The Bourtons Parish Council
Great & Little Bourton, Banbury, Oxfordshire

May 4th, 2021

Re : planning application 21/00922/OUT : Land west of Foxden Way, Great Bourton

ATTENUATION POND DETAILS
 DESIGN BASED ON IMPERMEABLE AREA OF 0.39HA INCLUDING A 10% ALLOWANCE FOR URBAN CREEP.

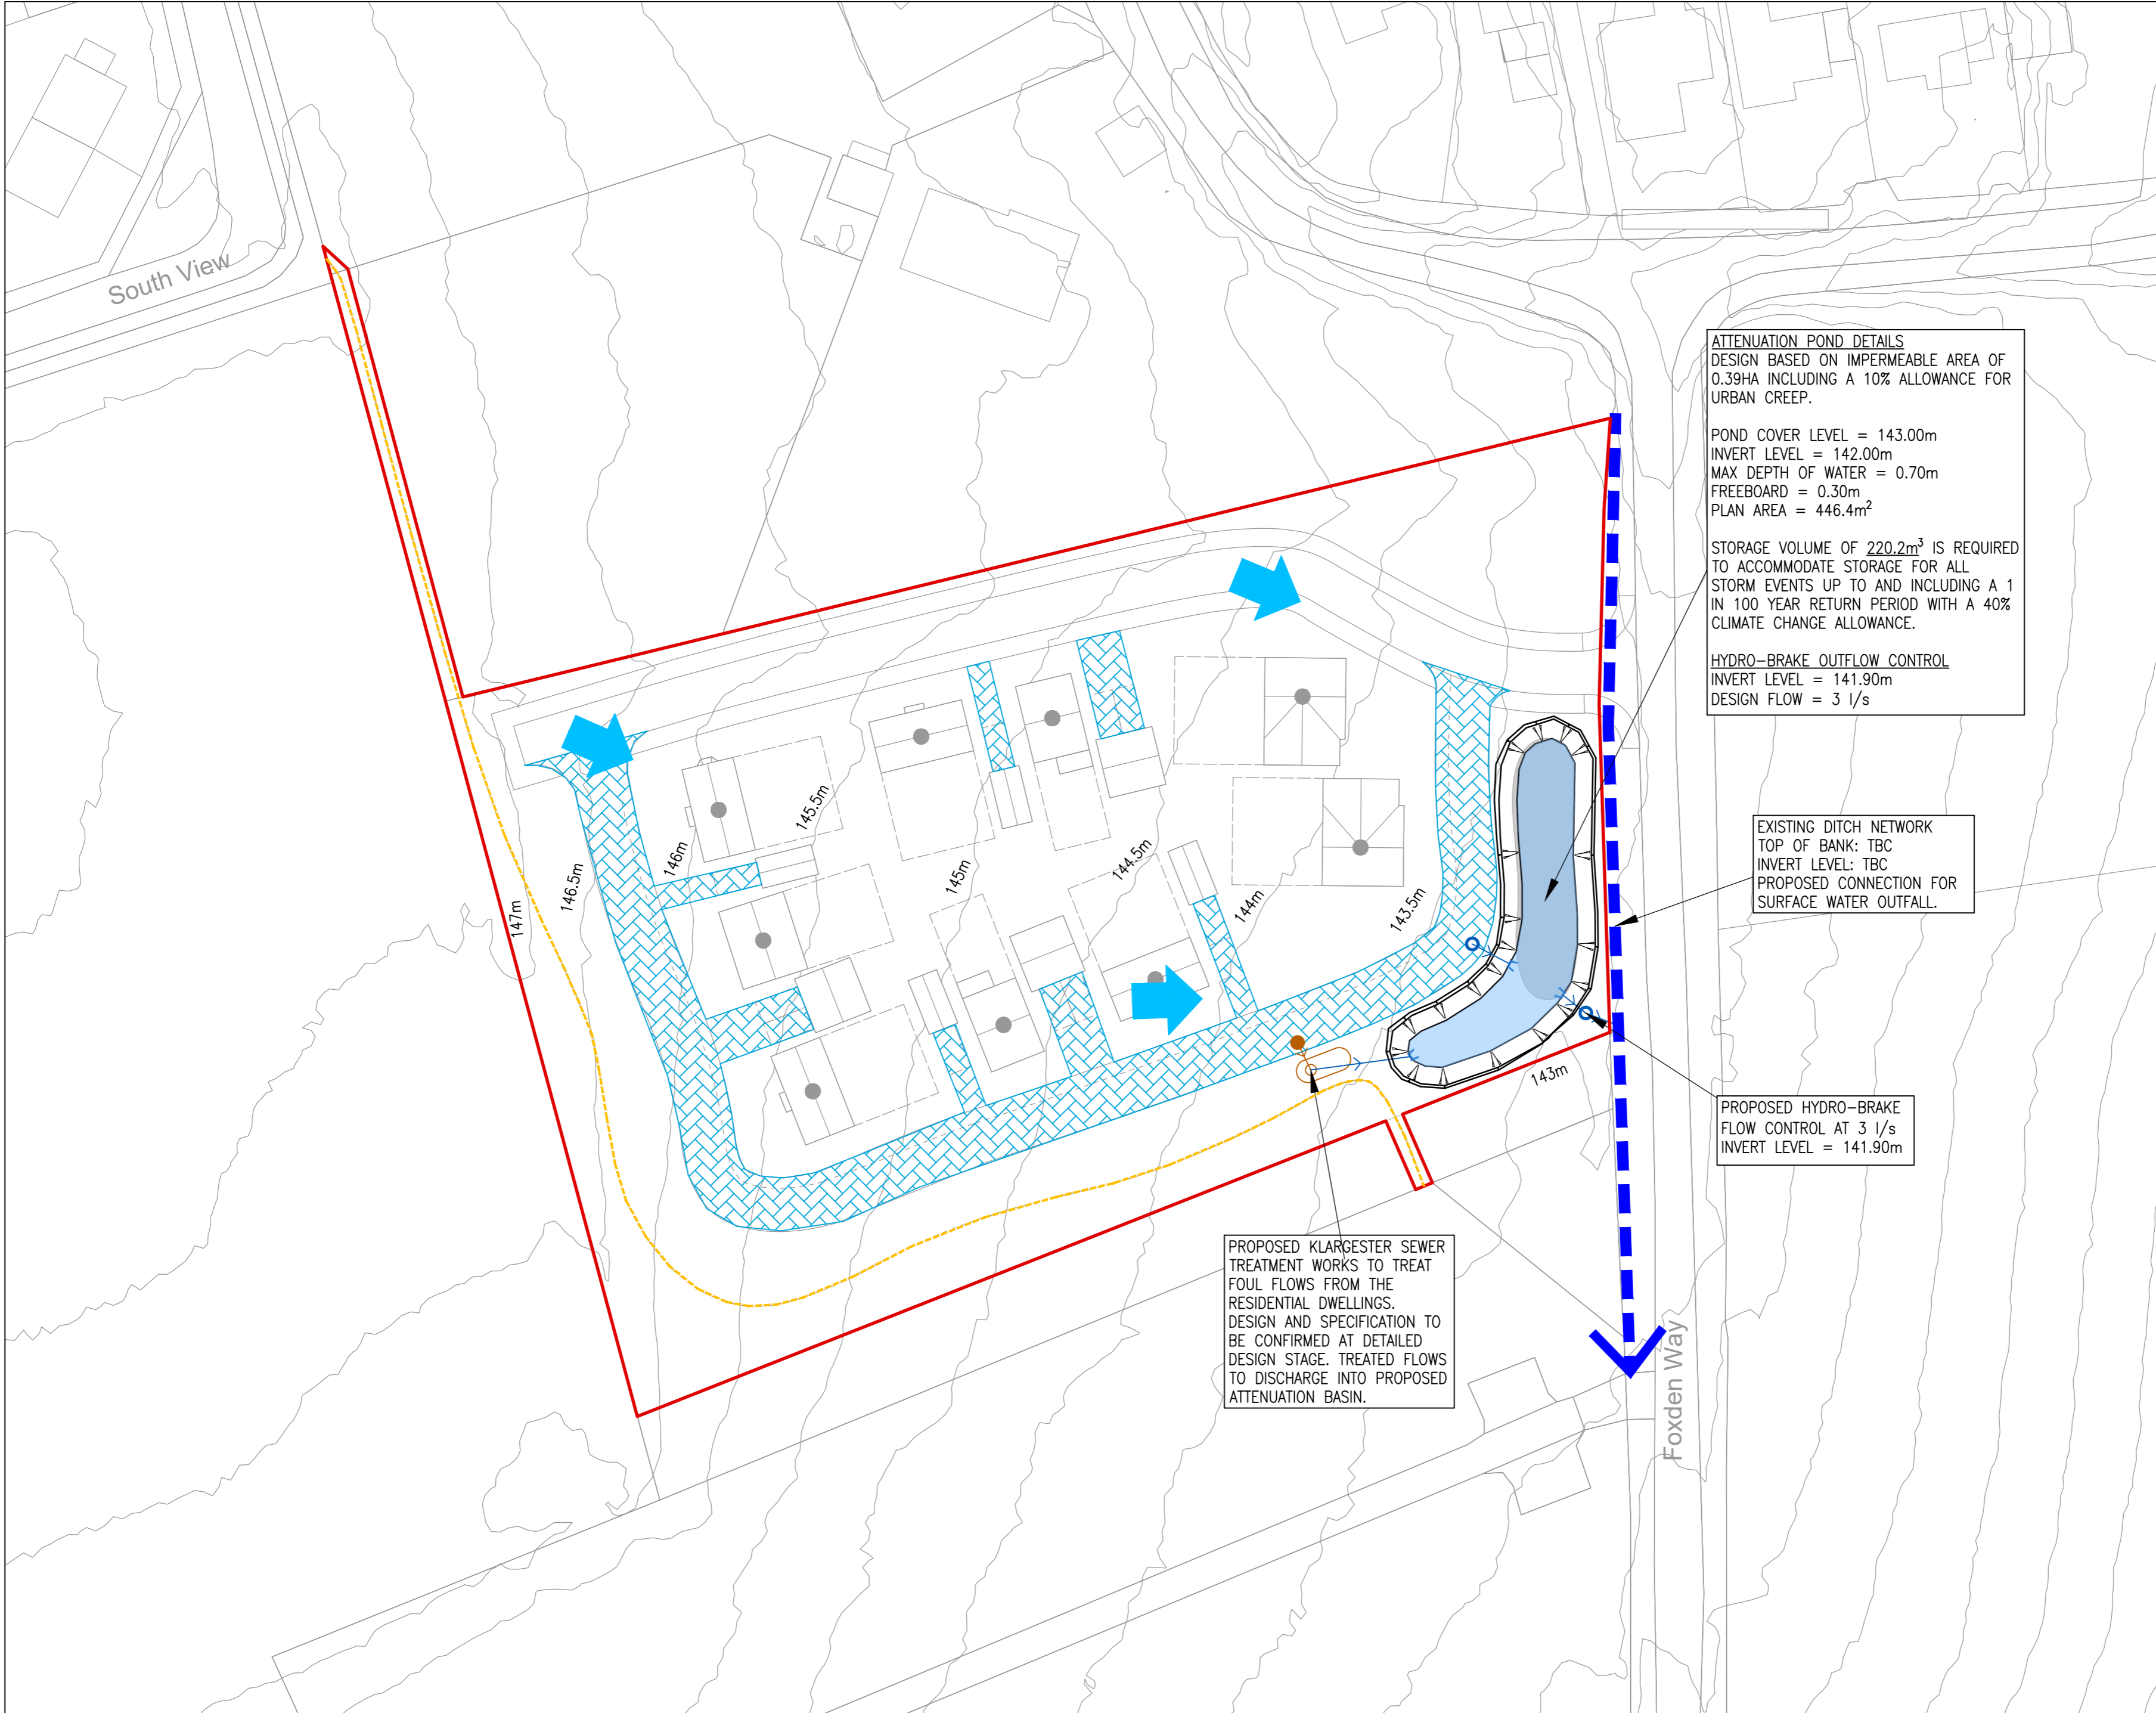
Watercourse: "A ditch is noted along Foxden Way and adjacent to the eastern boundary of the site. This is considered to be a viable outfall route for surface water flows from the site and is likely to receive existing overland flows from the site. This ditch course will therefore be the outfall location for surface water flows from the proposed development."

This can only be considered as a viable option if the applicant can provide a strategy for directing the outfall route in an uphill direction.

Tony Brummell in his drainage consultation document has said that water must be retained in onsite soakaways. This seems equally flawed, given the known impermeable nature of the local mudstone substrate.

"Foul water generated by the site will be collected and treated on-site via a Klargerster Sewage Treatment Plant or similar and will be discharged as clean water into the existing ditch network along the eastern boundary via the proposed attenuation basin. The detention basin will first be offered to bodies such as the Local Authority for adoption and future maintenance. Should this not be taken up, a management company will be employed."

If the ultimate plan is to direct the discharged foul water into the existing ditch network, we have the following comments following our investigations to similar installations:

It should be noted that the ditches in Foxden Way, two of which are the responsibility of the Parish Council, are not regularly maintained nor are they connected. We would therefore submit that if the planning officers are of a mind to accept this application, the proposed development should be connected to the main Thames Water sewage system.

Great Bourton ATC, School Lane (Southern Site)

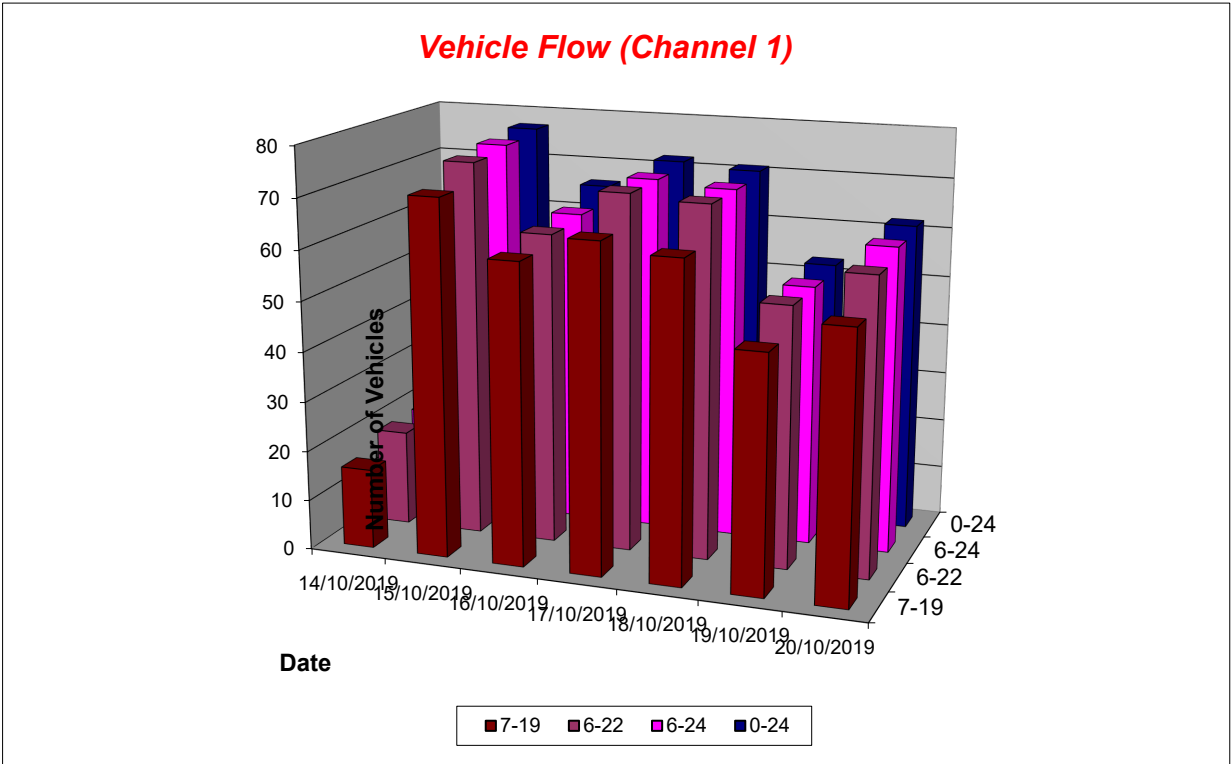
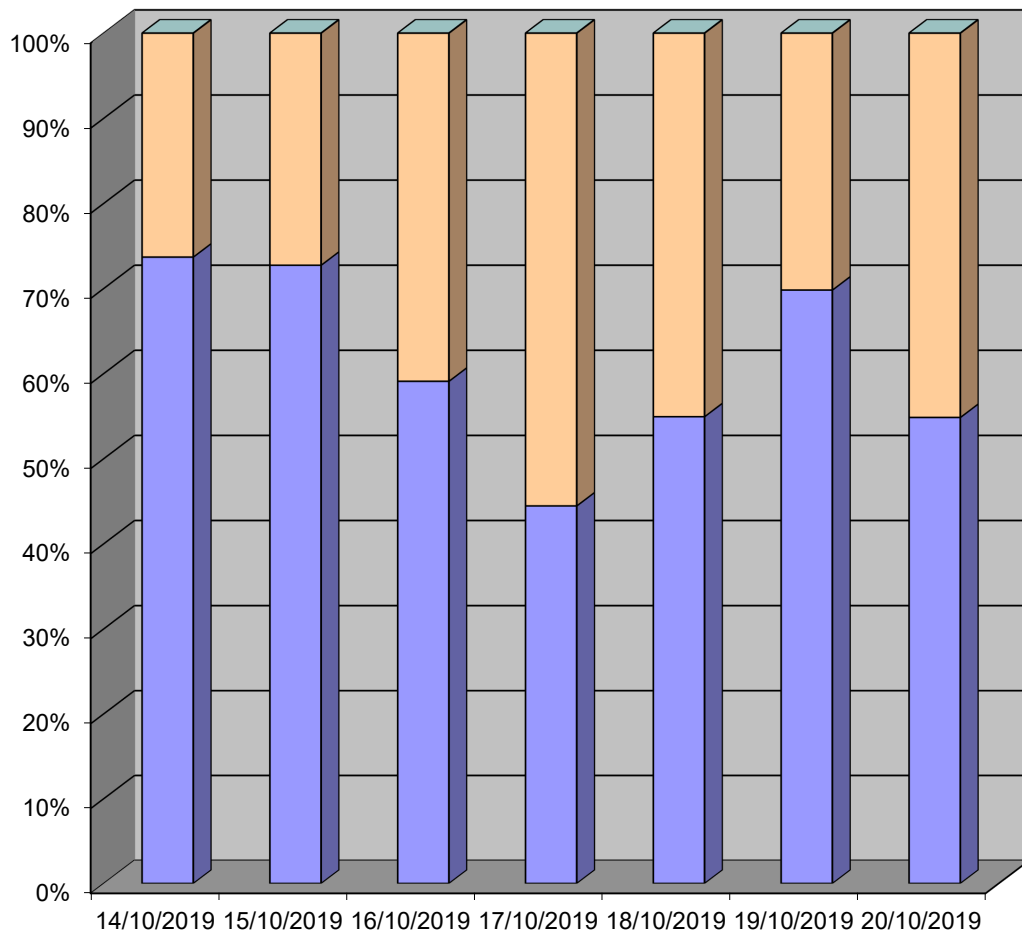
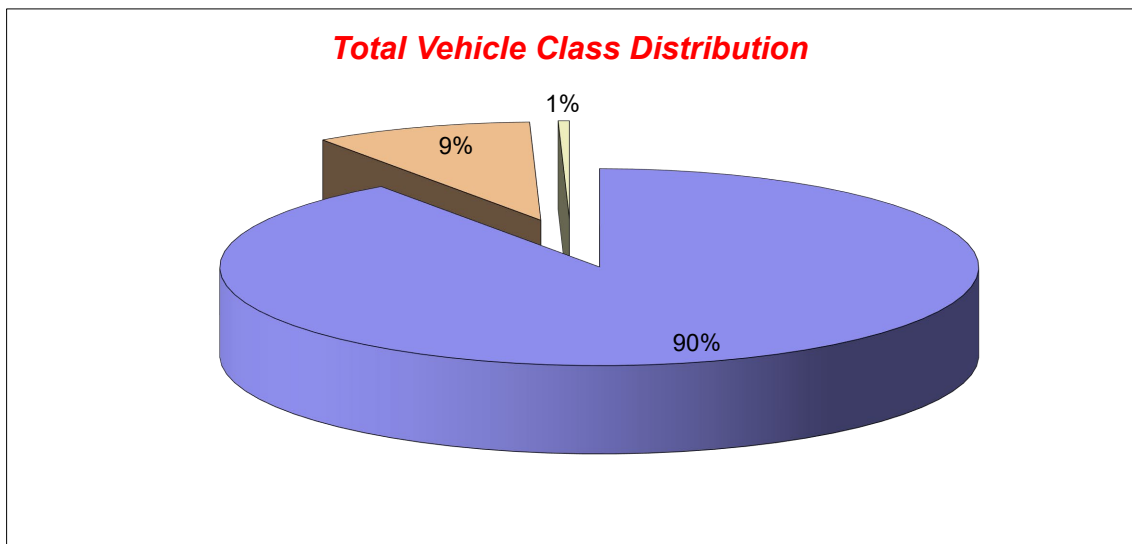
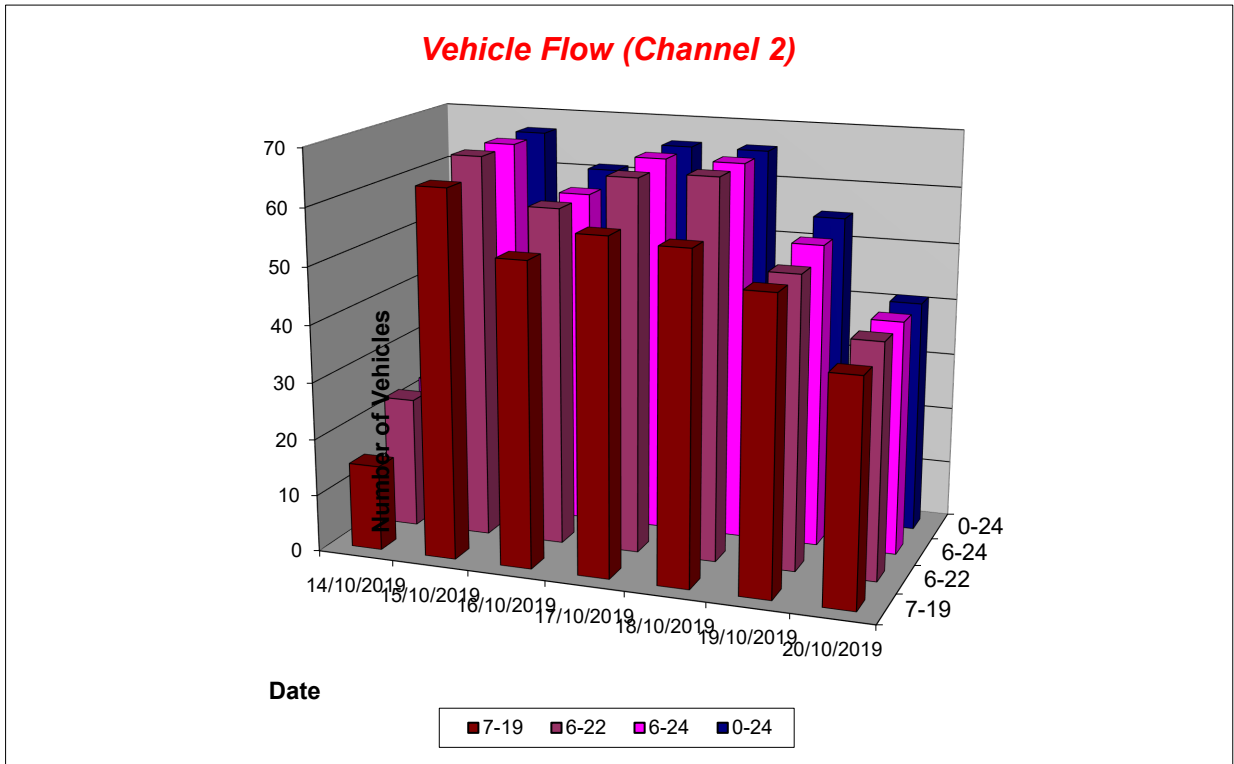
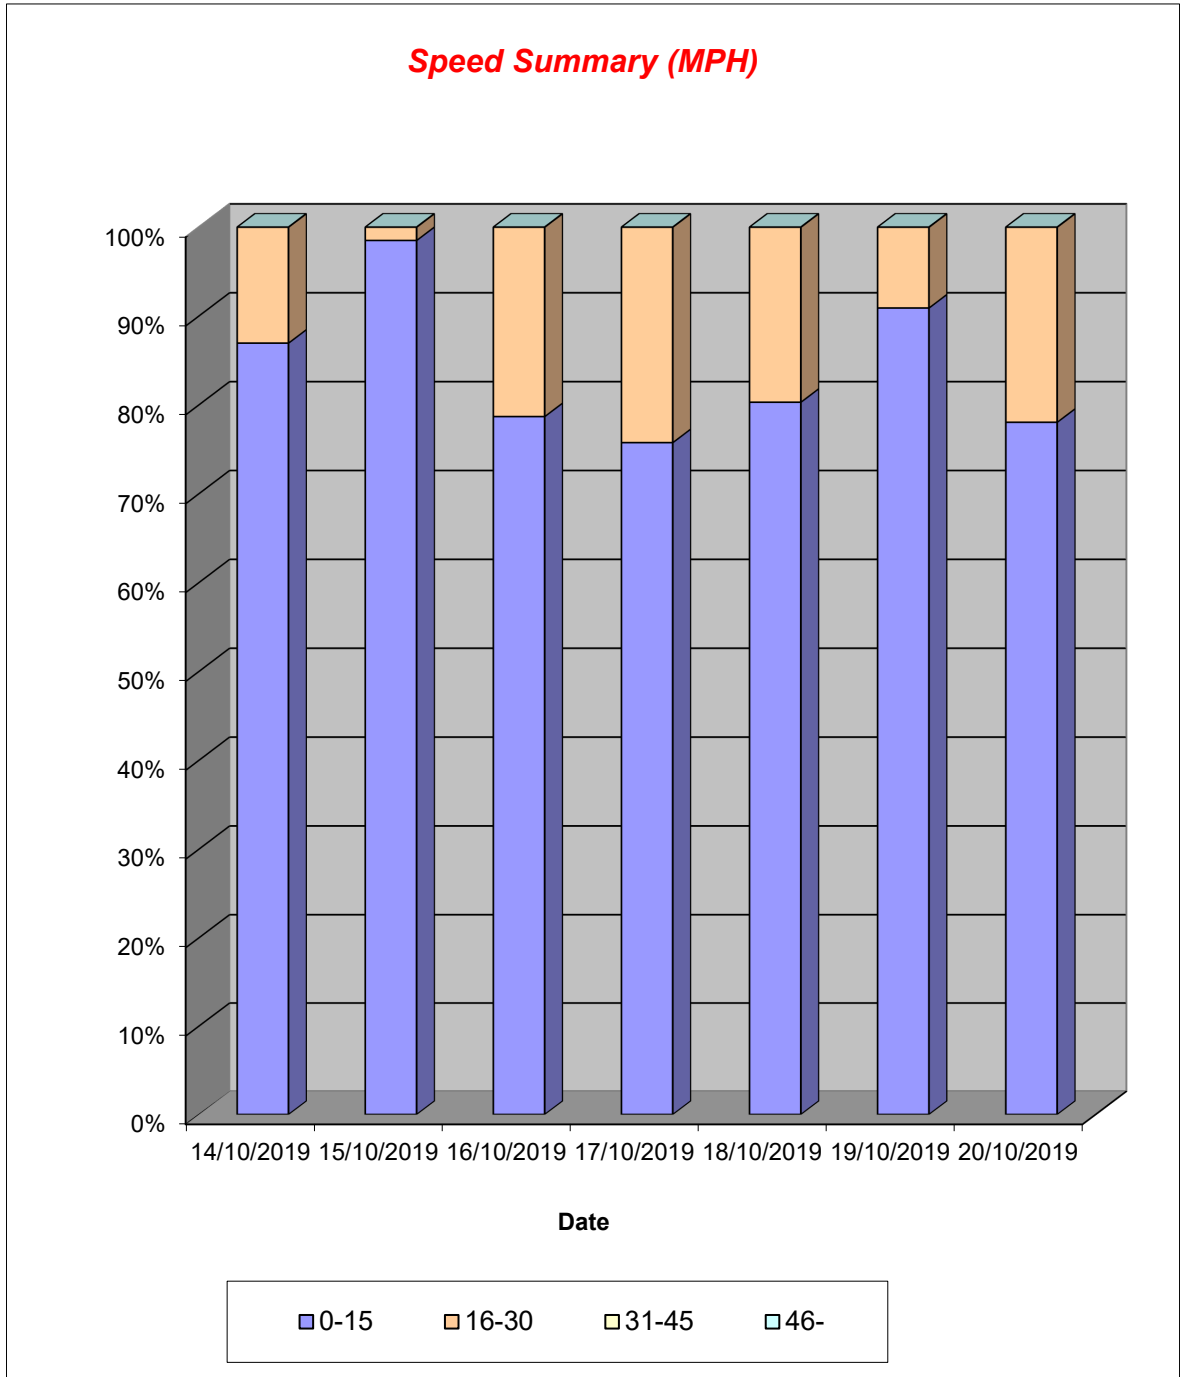
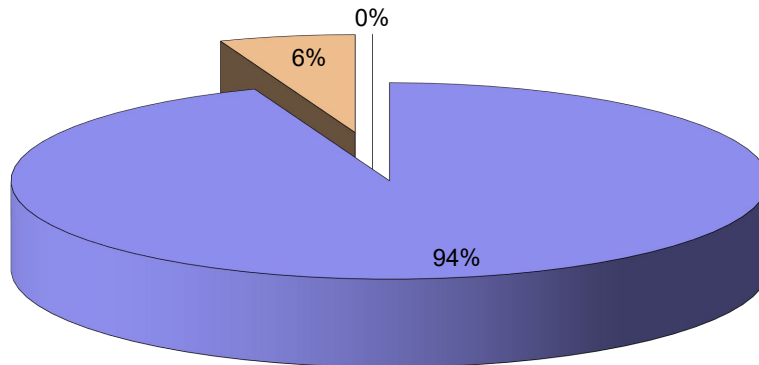
- f) The applicant has submitted the ATC which was carried out for their previous application ref: 19/01808/F. This related to School Lane only, so did not consider traffic from Crow Lane through Foxden Way and Spring Lane in Little Bourton, to access the Retail Park and Tesco's, used regularly by Cropredy residents. Bourtons Parish Council disputed the accuracy of this report since there were no recordings of farm vehicles for that week, which are regular and frequent vehicles using Foxden Way and School Lane. For the same period of time we carried out our own manual survey, the results of which were quite different from those submitted by the applicant albeit that our manual survey only covered the period from 8am until 11pm. Since then there has also been a 44 % increase in delivery drivers (measured against the national standards) to meet the demands of online shopping and the latest surveys predict that 9 out of 10 families will continue to use online shopping, so we don't anticipate a significant decrease in delivery vehicles.

- g) In view of the inadequacy of the applicants' ATC and its inappropriate reference for this new application, we have carried out our own traffic count on Foxden Way, the results of which will be forwarded to you before your decision date.
